MEMORANDUM

DATE: June 9, 2021

SUBJECT: PUDSP-20-005 – Falcon Meadows at Bent Grass (with EGP)
Fourth Submittal

DR-4

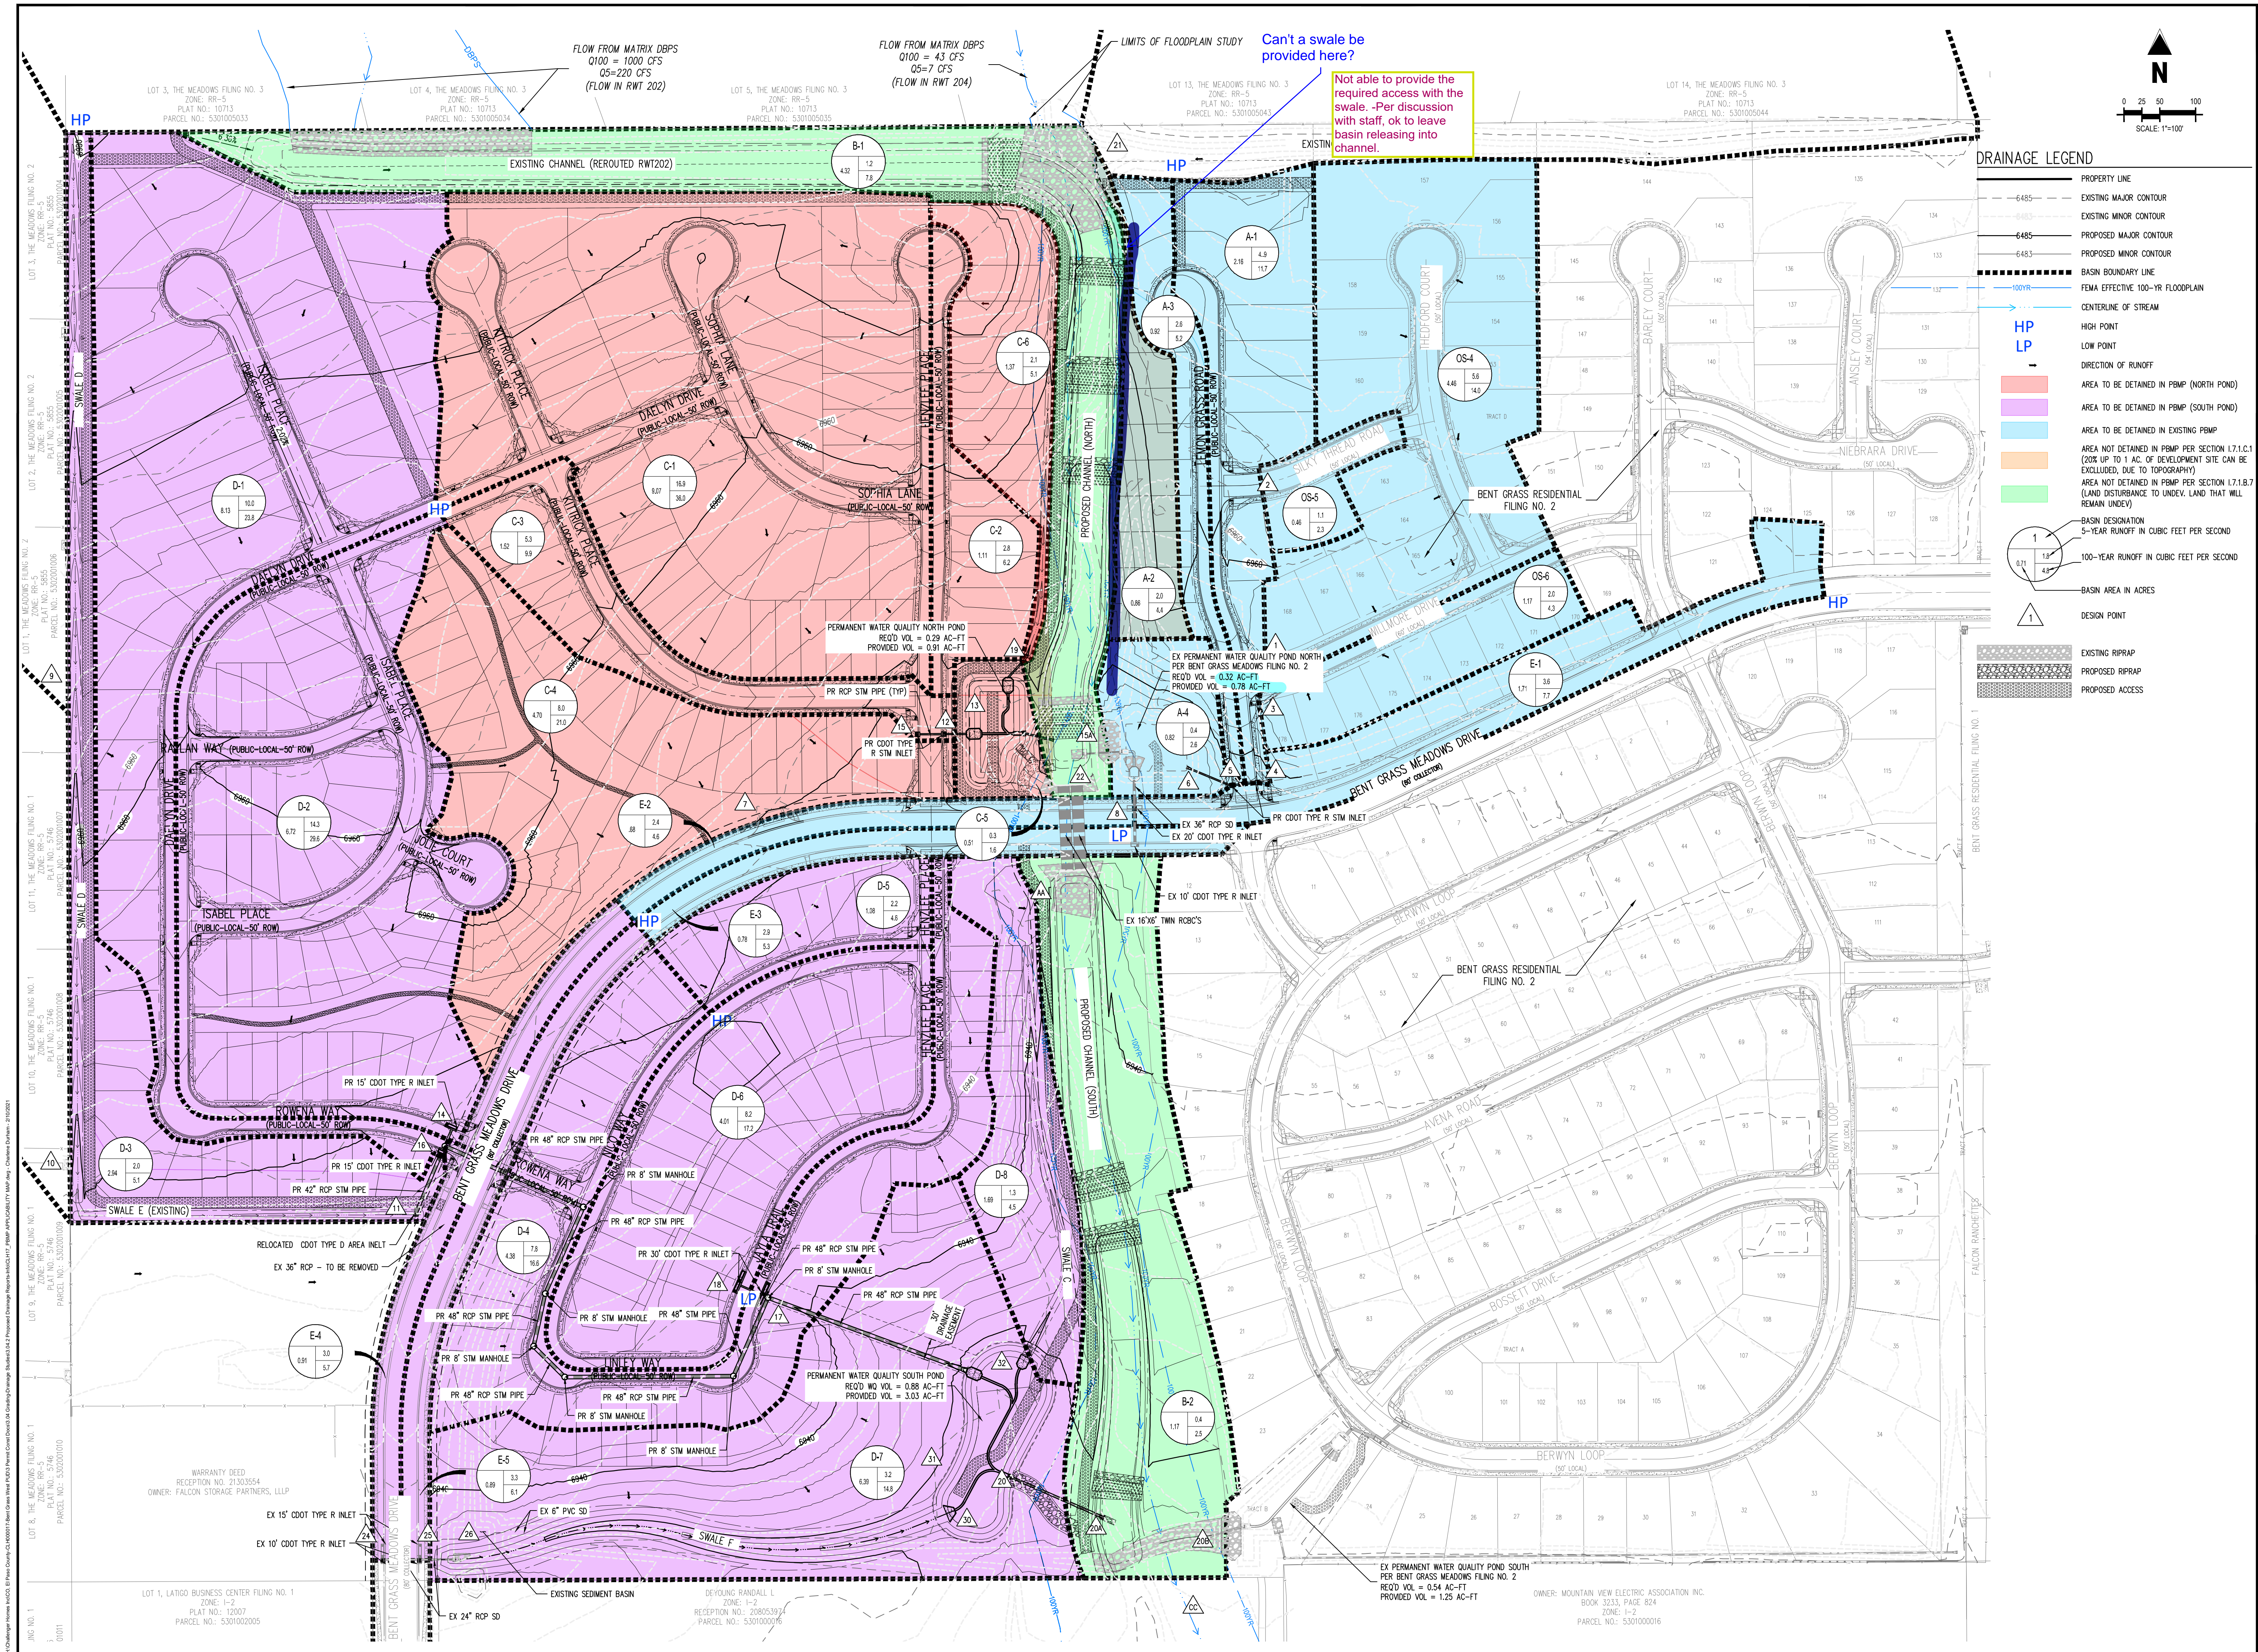
8. Address spillway design and FSD pond freeboard. Show the 100-year water surface elevations in the ponds and the channel. **Partially resolved;**
 - a. *Resolved.*

- b. The channel WSEs need to be shown. Provide a preliminary channel profile with the MDDP hydraulic modeling. *Unresolved.* **See MDDP redlines; update the PDR accordingly.**
Preliminary design of channel (Plan & Profile sheets, as shown in MDDP) which includes WSE have been included in report.

9. Resolved.
10. Resolved.
11. Provide channel and swale cross-sections and drop/check structure design on the plan. Provide a channel plan and profile. **Unresolved.**
At this time, no changes are being proposed from what is shown in the DBPS. Copies of the details from the DBPS have been included in the appendix, as also shown in the MDDP. Statement regarding design of channel, as included in MDDP, has also been added to this report
